TR010063 FORMAL OBJECTION AND HUMAN RIGHTS ISSUES & Written summaries in response to the Applicants points raised up to & including 11/11/24

From ref: no 20047638 – Deadline 8a

Therefore I still **formally and strongly object** to the latter section of the proposed spur road, between the northern side of the B4634 Old Gloucester Road into part of the West Cheltenham Strategic Allocation on the following grounds:

ACCESS TO WEST CHELTENHAM
DEVELOPMENT AREA (GOLDEN VALLEY)

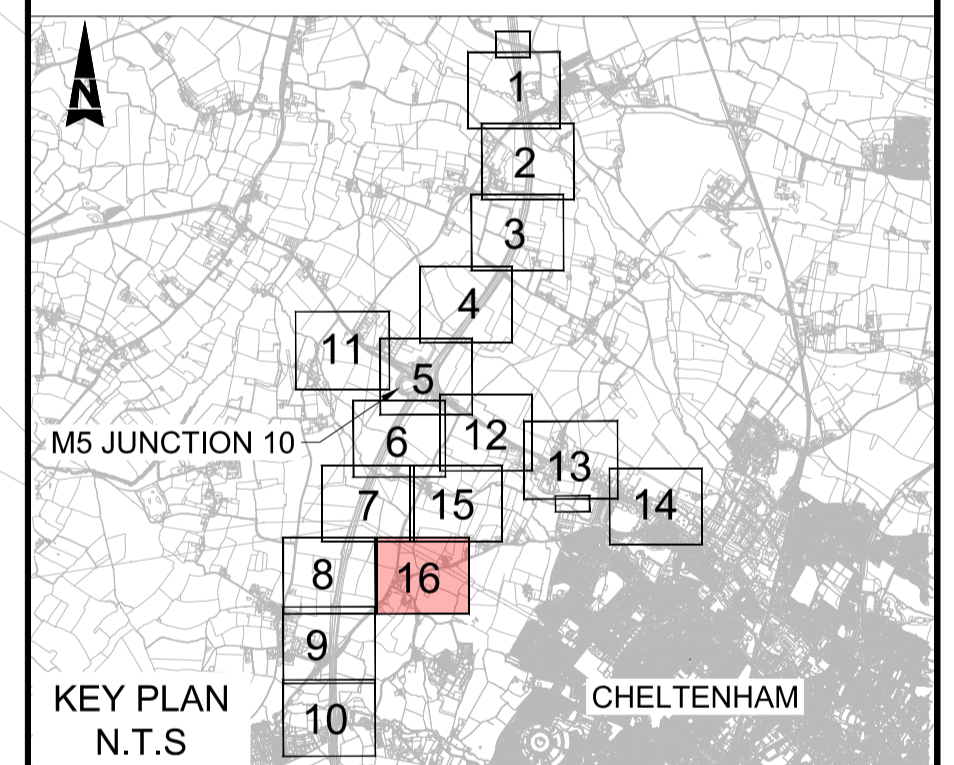
I cannot connect to the junction design GCC have put in place when it clearly it does not abut my boundary. The scheme does not contribute in any way to the development potential of my site. As I said on day one of the Inquiry a roundabout would have solved the issue.

It seems that the applicant has ‘assumed’ (Applicants word) to much regarding the design of the B4634 junction and I think this is the root of the problem, that’s why I am arguing against the design. It should be for the developers of West Cheltenham to agree an access as the SPD does not have a definitive ‘planning status’.

The spur road Junction onto the Old Gloucester Road.

- 1) The designed scheme substantially affects my allocated site, by restricting development access and therefore in my case the scheme does not meet **the key objective set out in the JCS to provide housing.**

- 3) Without any consultation with me the applicant decided to then change the scheme to a signalled junction, which obviously seriously affects my site to the extent I have been discriminated against in preference to the submitted scheme giving sole access to my neighbours site only. This is highlighted by the fact the main spur road alignment would have carried on into my site, but instead it has a curve taking it away from my site into the next field.
